Kirklees Council
Planning and Development Service
PO Box 1720
Huddersfield
HD1 9EL

Date: 20-Mar-2023
Our Ref: 2022/92766

**Application for Approval of Details Reserved by Condition
Town and Country Planning Act 1990
Planning (Listed Buildings and Conservation Areas) Act 1990**

**Discharge conditions 5 (construction traffic access), 6 (methodology of works), 7 (Site Investigation Report), 8 (Further Intrusive Investigation), 9 (Remediation Strategy), 10 (Remediation of the Site), 11 (Validation Report), 12 (materials), 14 (crime prevention), 17 (external lighting) on previous permission 2019/91524 for alterations to former coal chutes to form 9 two storey storage units (within a Conservation Area)
off, Low Westwood Lane, Wellhouse, Golcar, Huddersfield, HD7 4EW
Application Number: 2022/92766**

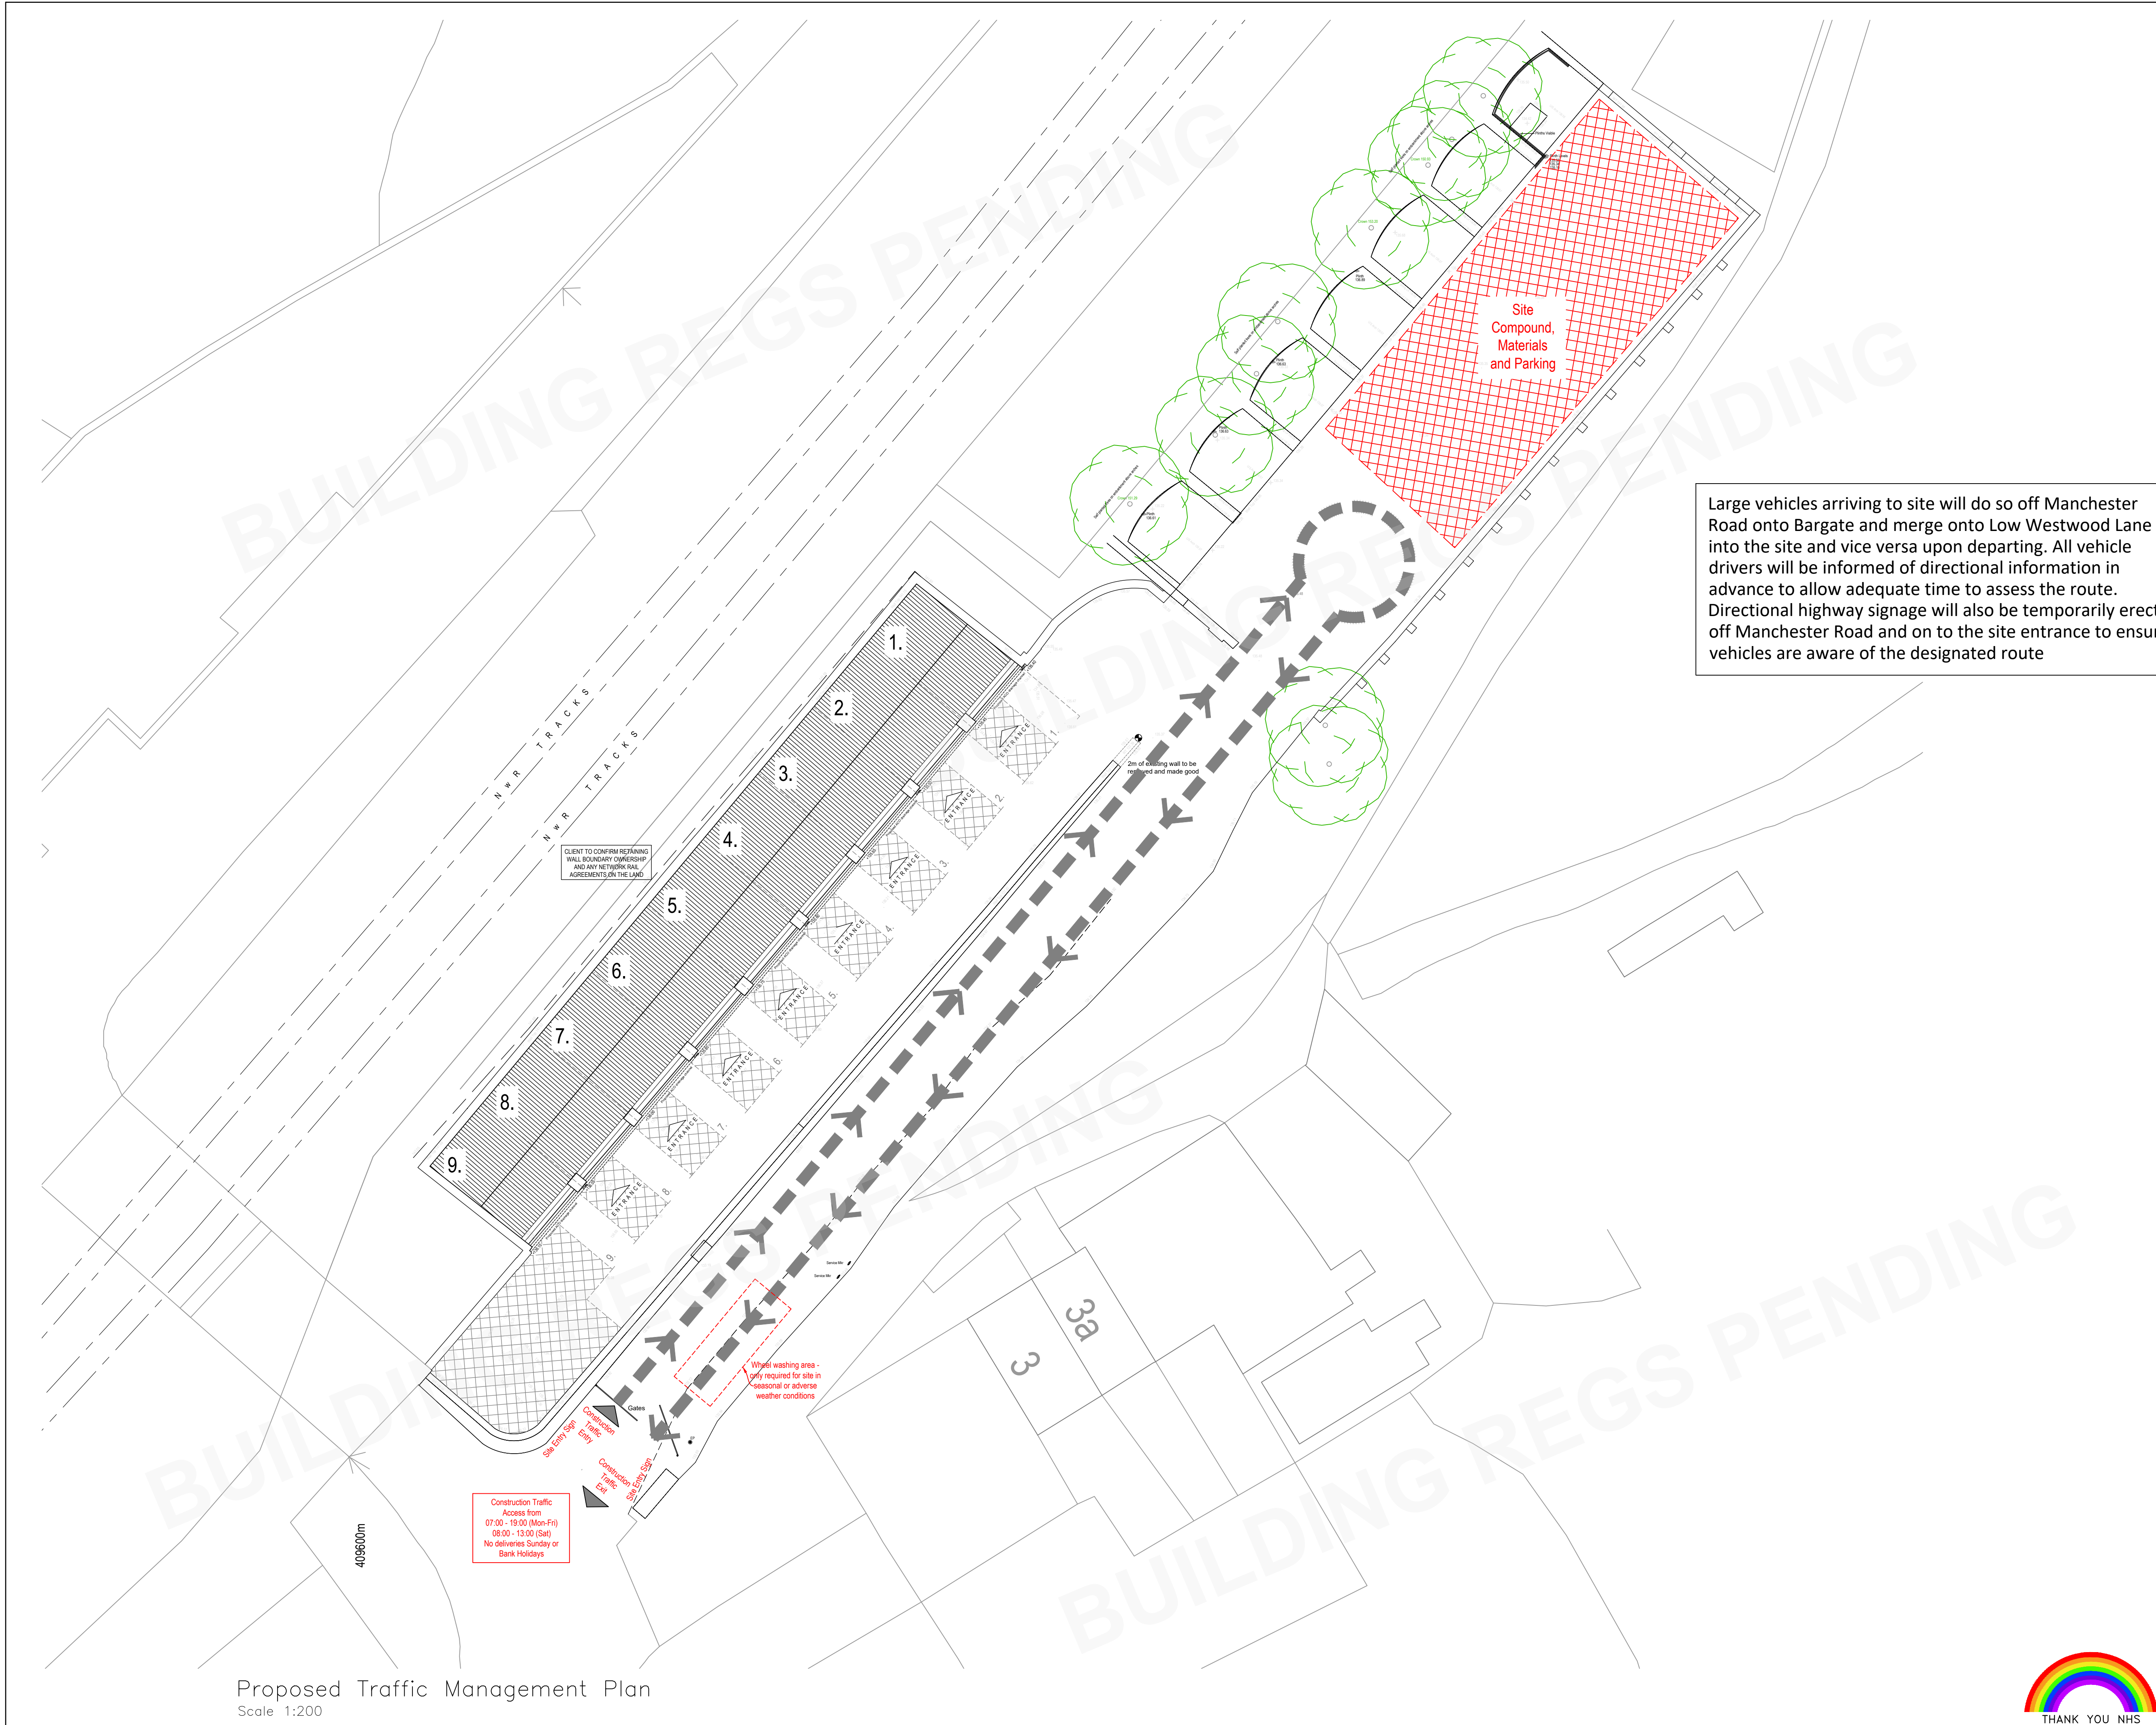
- Traffic Management Plan (Drawing no. 110-22-BR10 Revision A).

The details submitted in relation to Condition 5 are acceptable and Condition 5 can be discharged following the construction of the development in accordance with the approved schedule.
